East Park Energy

Environmental Statement

Appendix 4-3 EIA Scoping Opinion Response Matrix

September 2025

Drawing Title
Indicative Construction Access and Compounds
Sheet 2 of 5

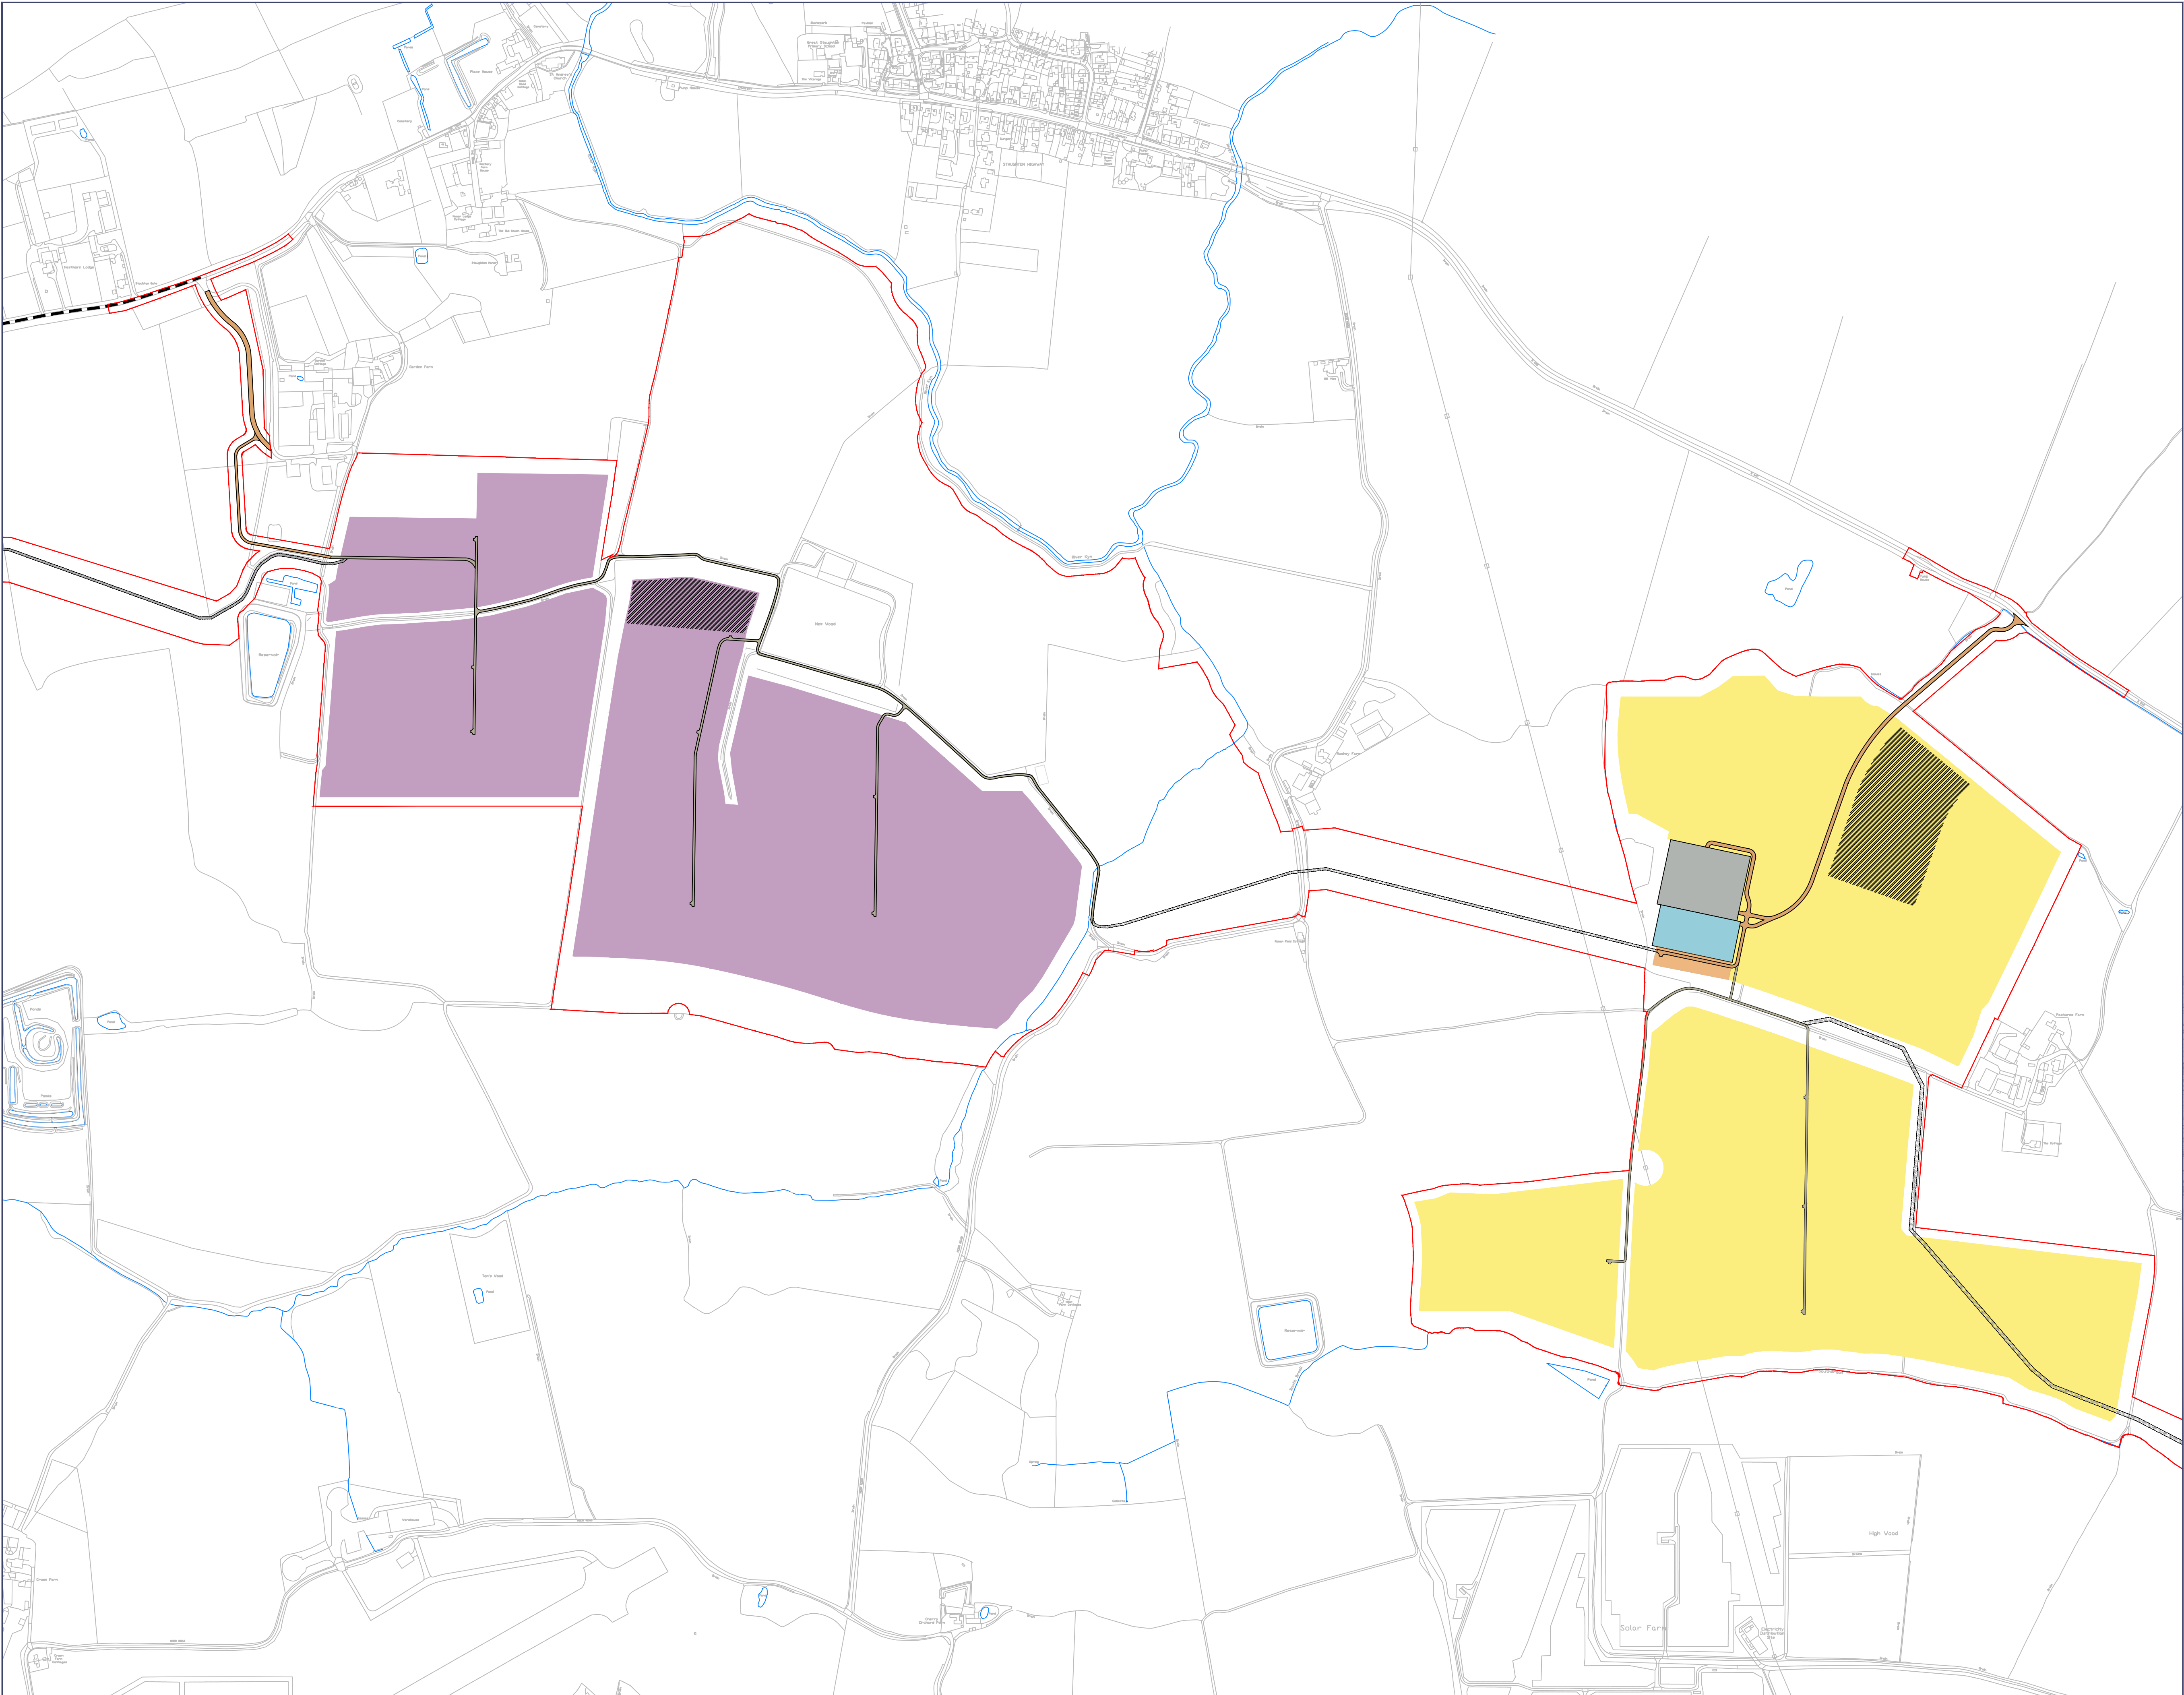
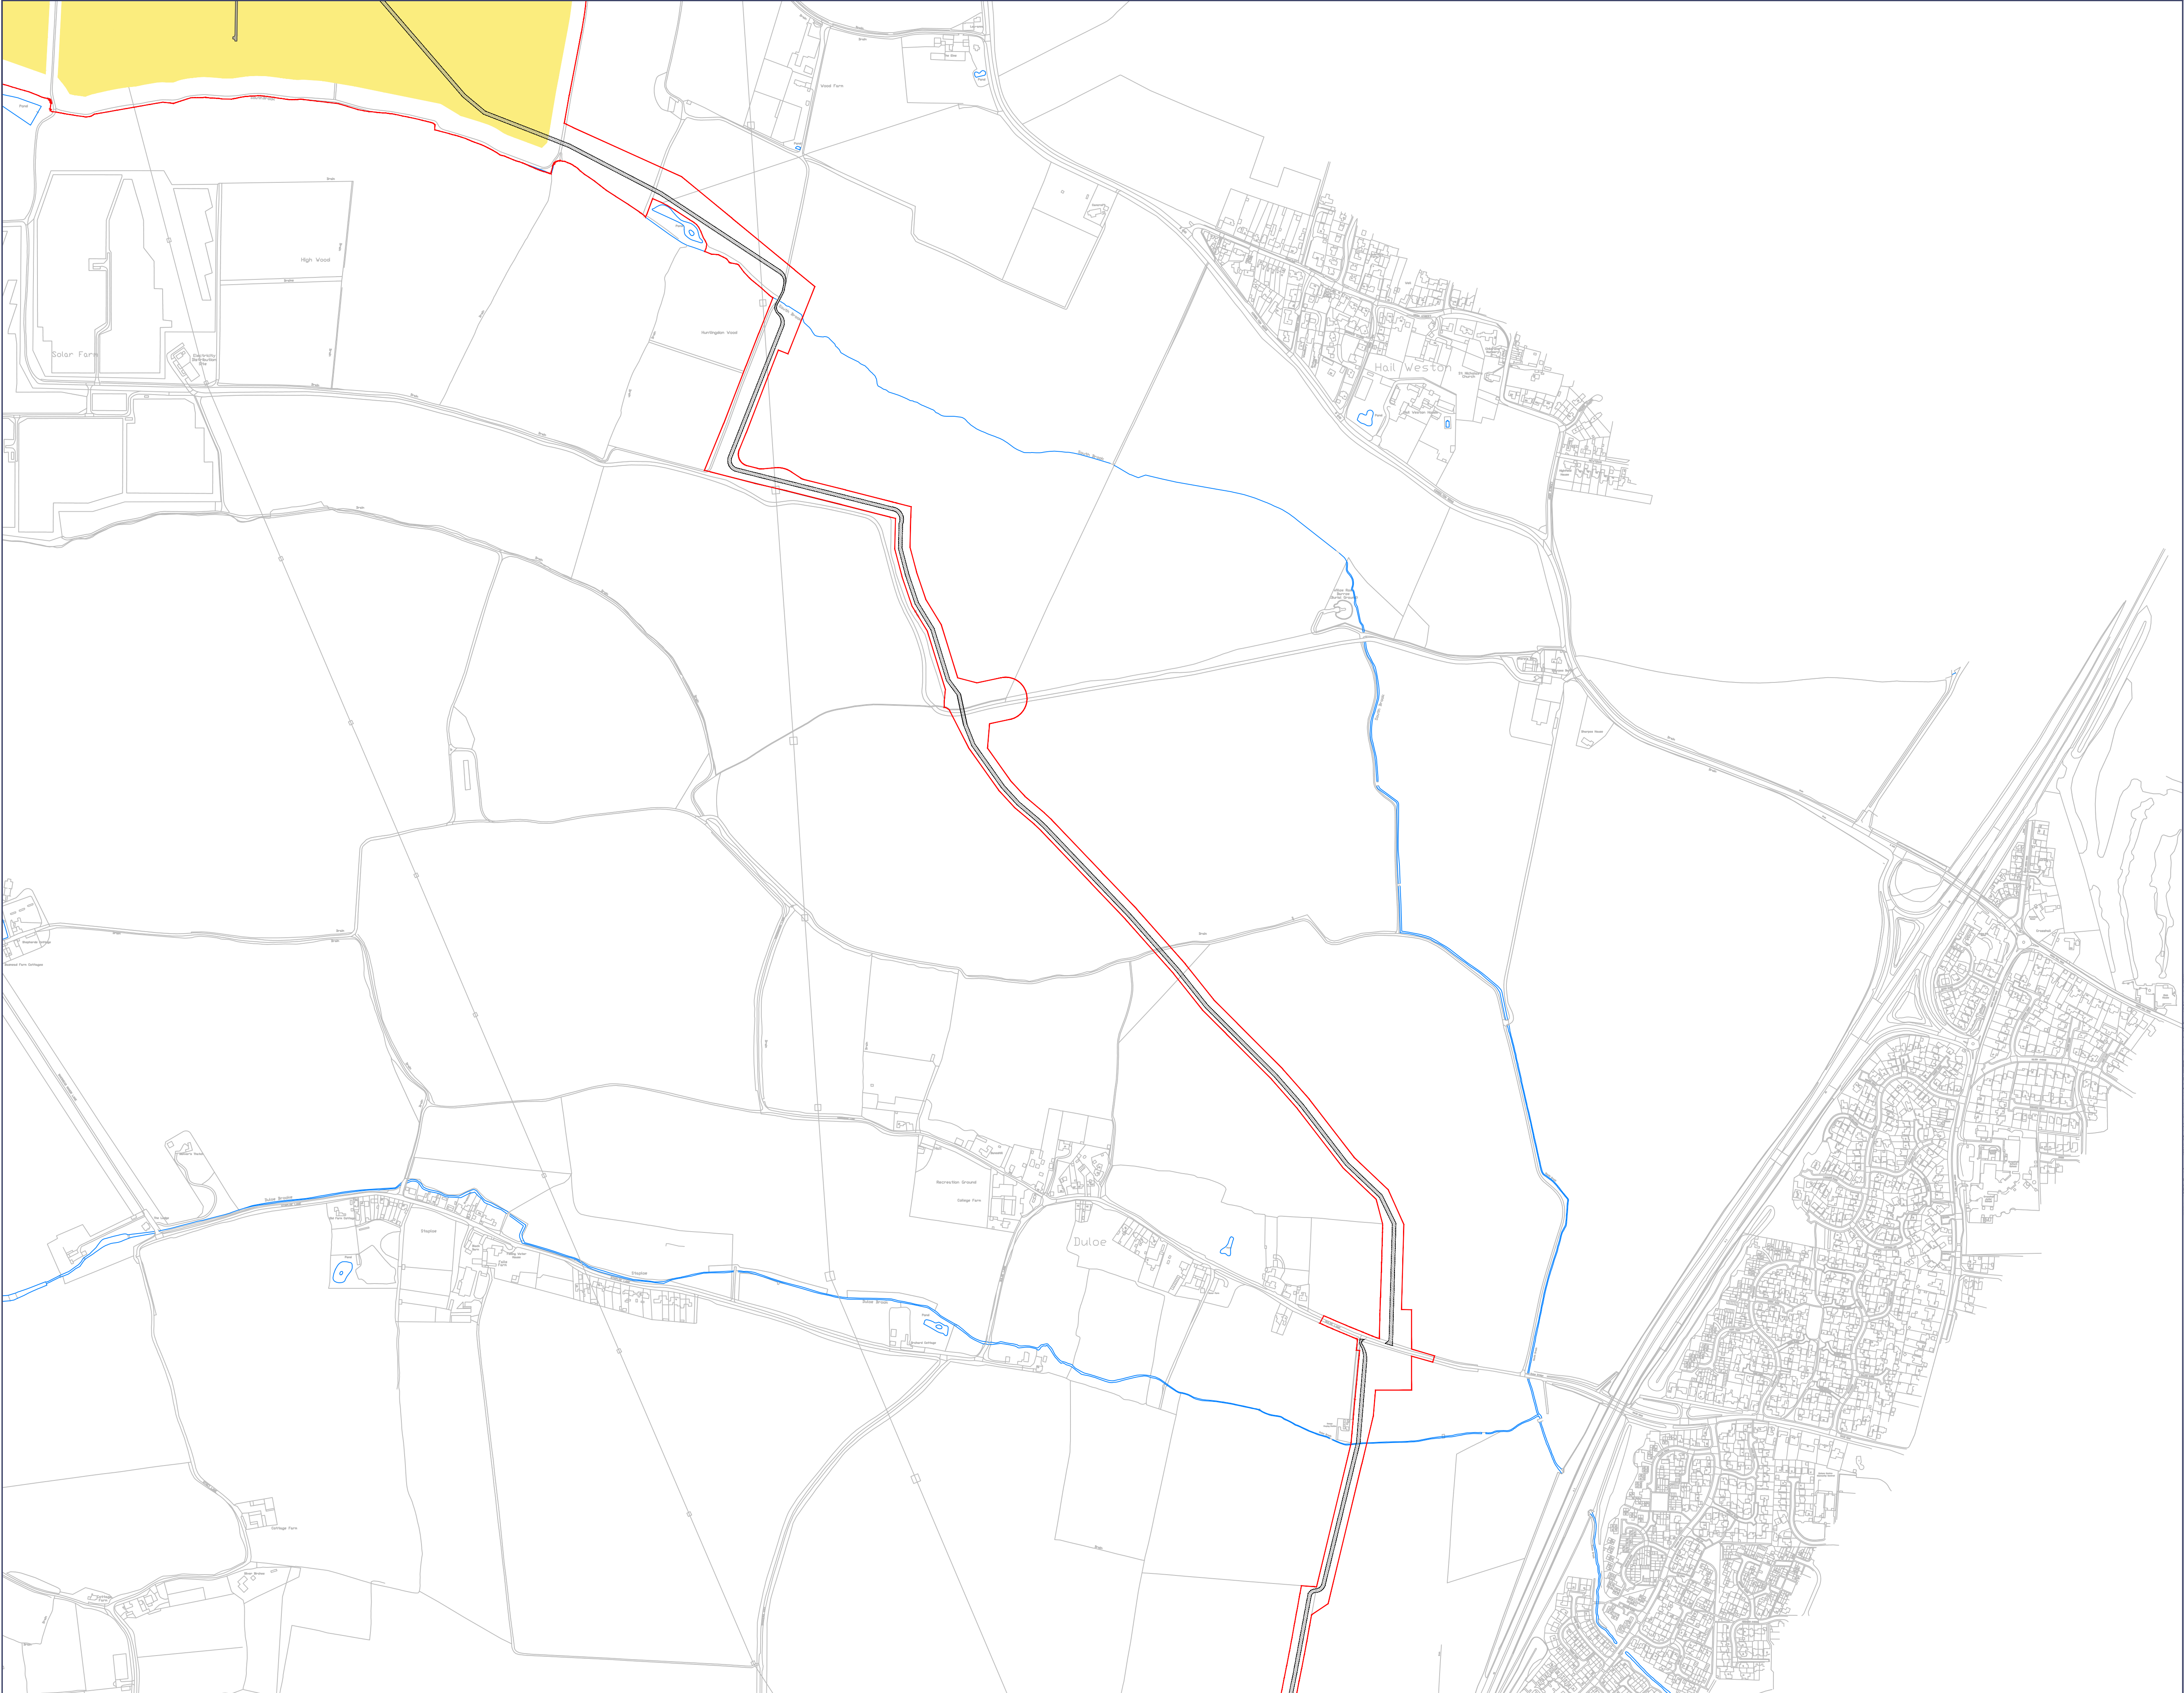
2.1.4	<p>Construction compounds</p> <p>The Scoping Report states that the Proposed Development would require one or more temporary construction compound(s) within the site, however, the exact location is yet to be determined. To ensure a robust assessment of likely significant effects (LSE), the ES should provide details regarding the number, location and dimensions of construction compounds.</p>	<p>The location of the temporary construction and decommissioning compounds are shown on ES Vol 3 Figure 2-5: Indicative Construction Access and Compounds, and secured by the limits of deviation of Work No. 7 as shown on the Works Plan [EN010141/DR/2.3].</p>
